Application: SSI 7485

I write regarding the proposed modification to M4-M5 Link, Mod 2 The Crescent overpass and changes to pedestrian infrastructure in North Annandale, Rozelle and Rozelle Bay Foreshore area.

Figure 4-2 Pedestrian and cyclist bridge infrastructure options

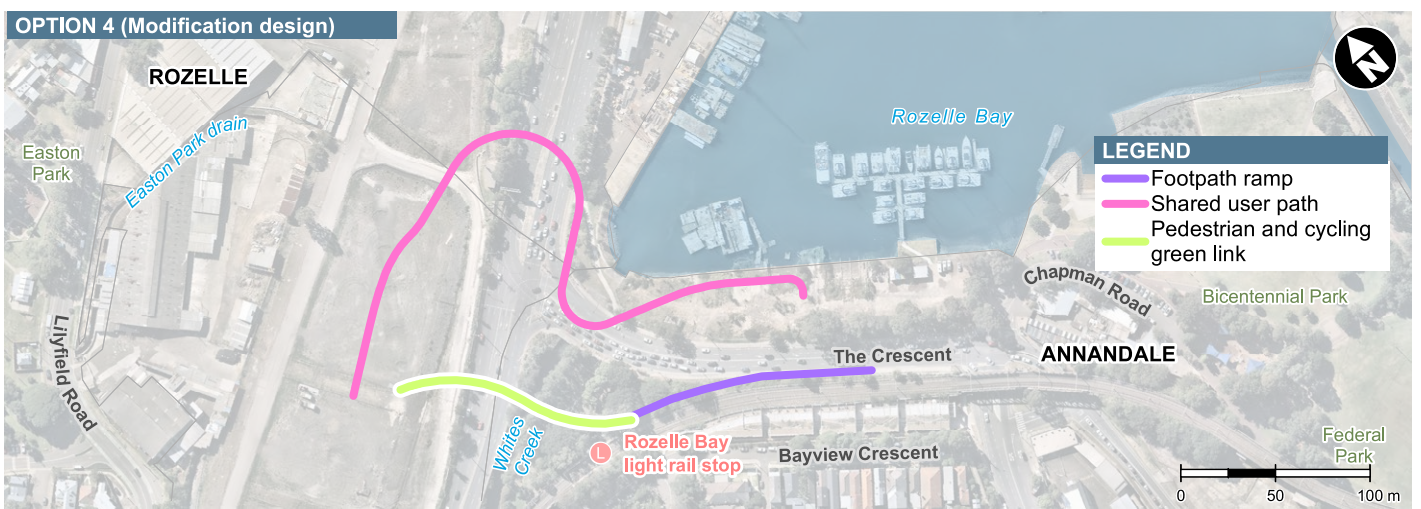
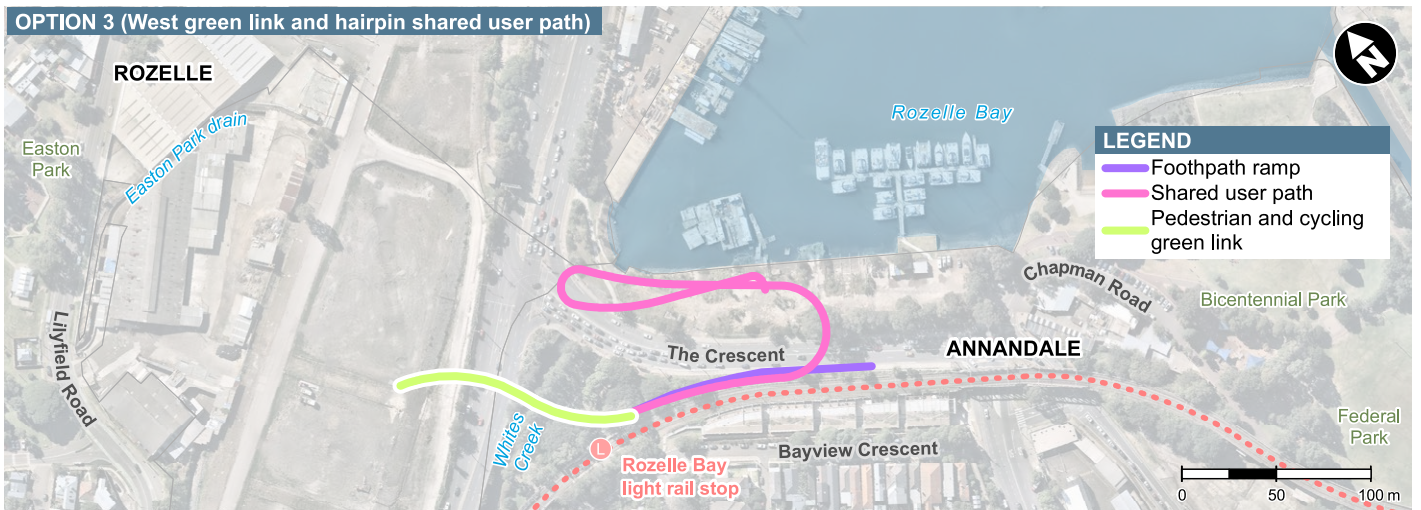
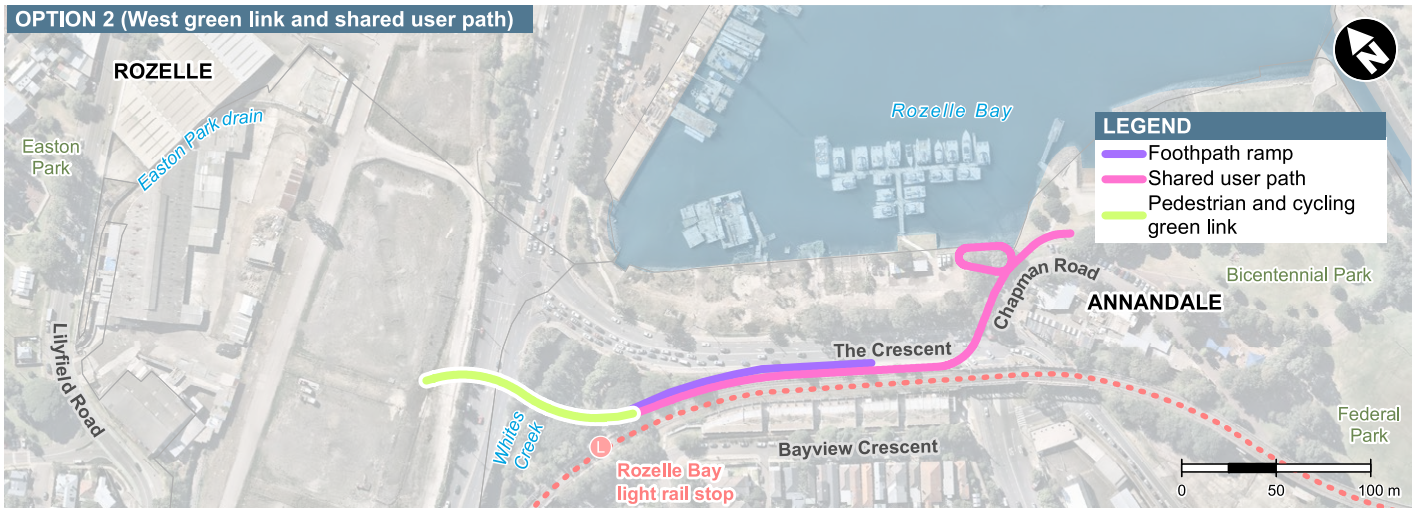
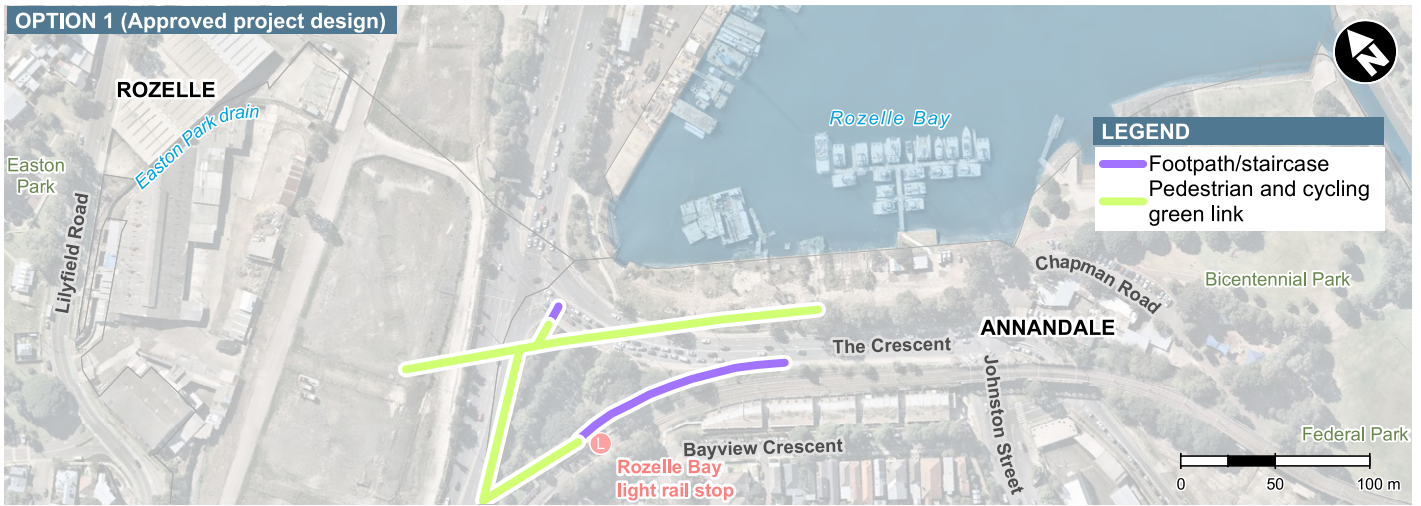
I request RMS work with the community to explore alternate design options to the proposed new car overpass design and the changed pedestrian and cyclist links. I am seeking the reinstatement of the safe, direct access from the approved EIS GreenLink to create a continuous green open space connection from the Rozelle Rail yards and Annandale to the foreshore. The GreenLink was more than just a walk way - it put people central to the design, maximising safety, and providing much needed accessible open space for the community now and into the future Bays Precinct design.

- The significantly reduced safety and increased risk for pedestrians and cyclists with removed access over The Crescent to Bicentennial Park and the increased traffic along Johnson Street.
- Being required to cross five sets of pedestrian lights at The Crescent as my option to reach the foreshore from Annandale or from Rozelle Bay light rail stop.
- Removal of direct active links to the foreshore, cutting the community off from the area and the proposed revitalisation of the entire Bays Precinct, including linking the Light Rail and Bus stops to a Ferry wharf and Metro station.
- Urban and landscape design that is being built before a finalised Masterplan for the area.
- Traffic changes that limit movements around the suburb and create further congestion in the local streets of Annandale, Forest Lodge, Glebe, Lilyfield and Rozelle with no planning to deal with these.

- Reinstate the GreenLink connecting communities and green open space from Rozelle to Bicentennial Park
- Relocate and design pedestrian and cyclist connections that are continuous, safe and direct.
- Design the modification infrastructure and active links in response to the character of the suburbs, the location of the foreshore and it's potential future development.
- Provide pedestrian and cyclist paths that maximise people safety and do not force them onto busier streets, unsafe concrete plazas and caged walkways.
- Integrate active and direct connections to all active transport – including the future Metro West and Foreshore Ferry Wharf

Figure 4-3 The Crescent, Johnston Street, Chapman Road intersection options

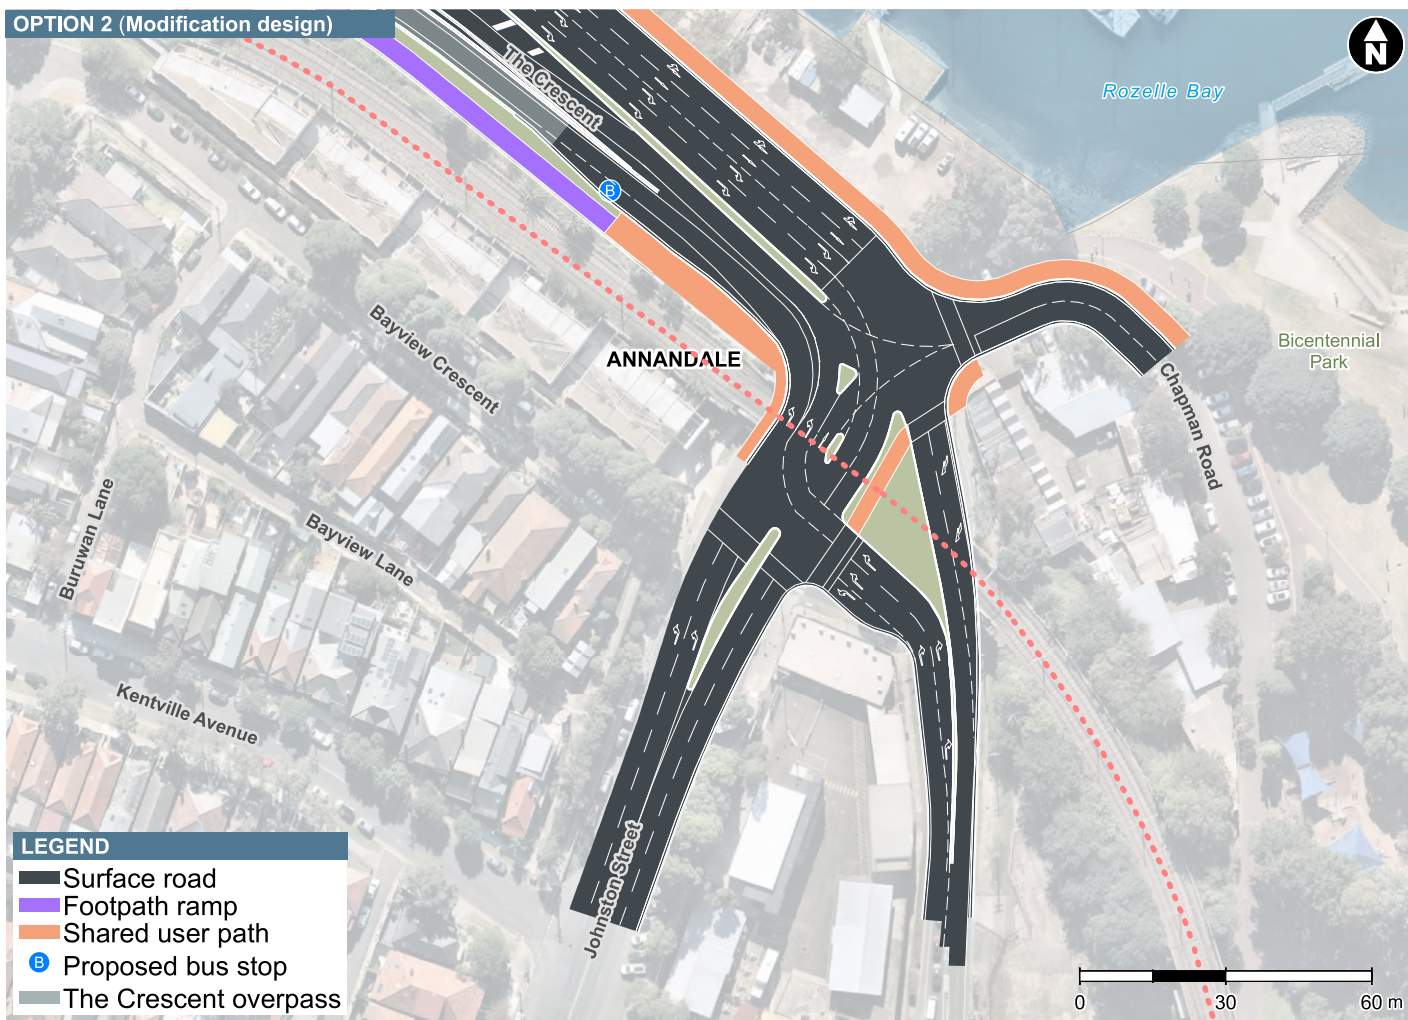
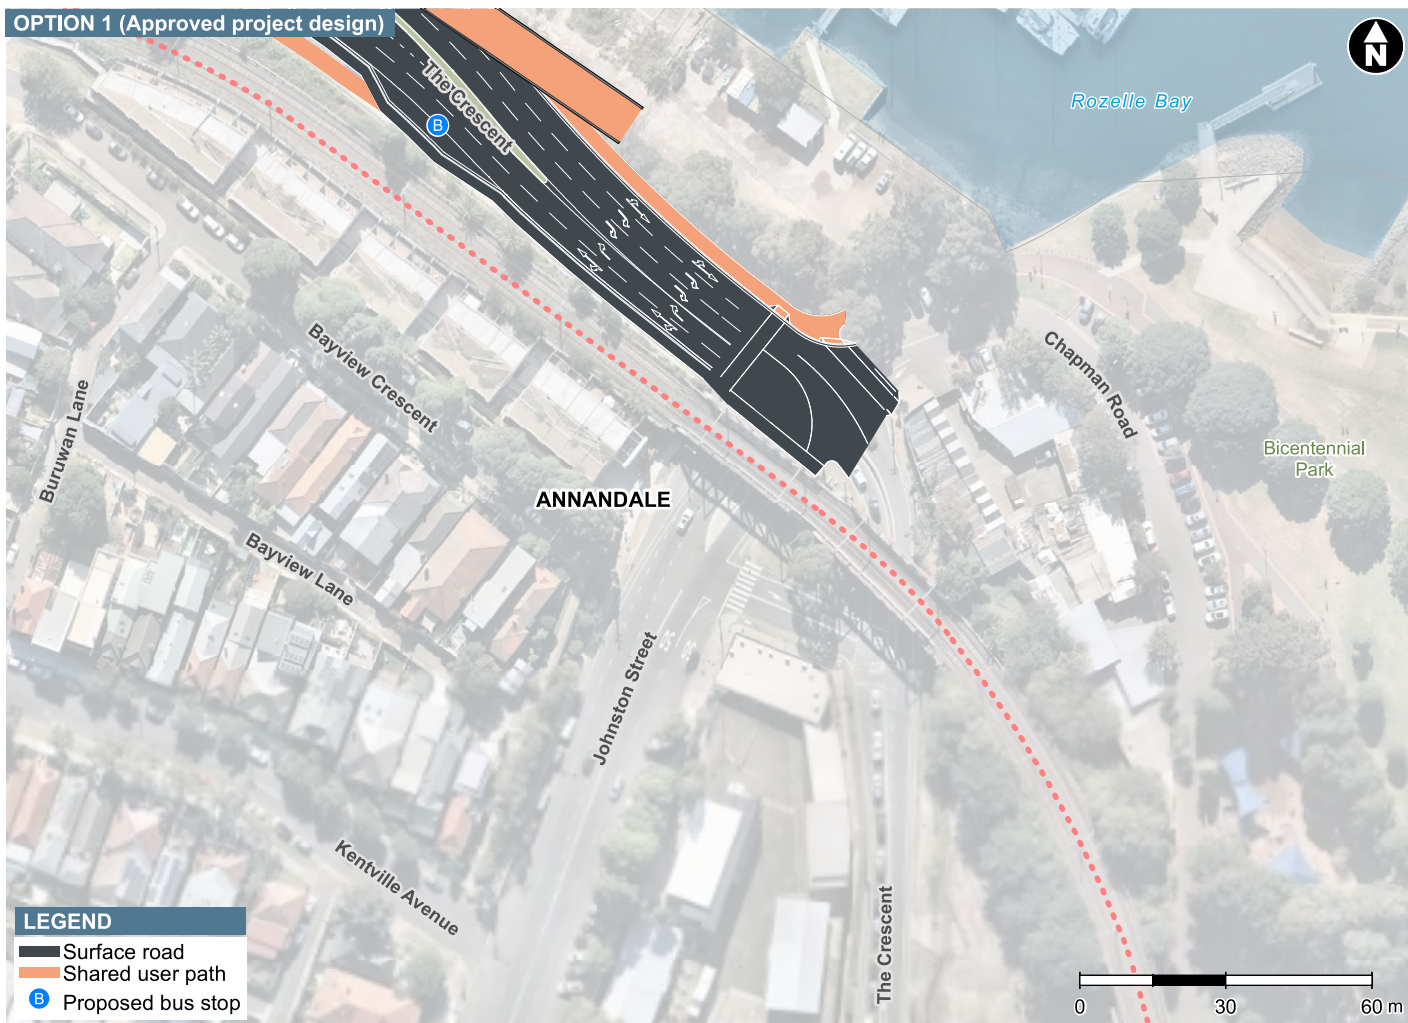
There needs to be the ability to turn right from Johnston St in
to the Crescent.
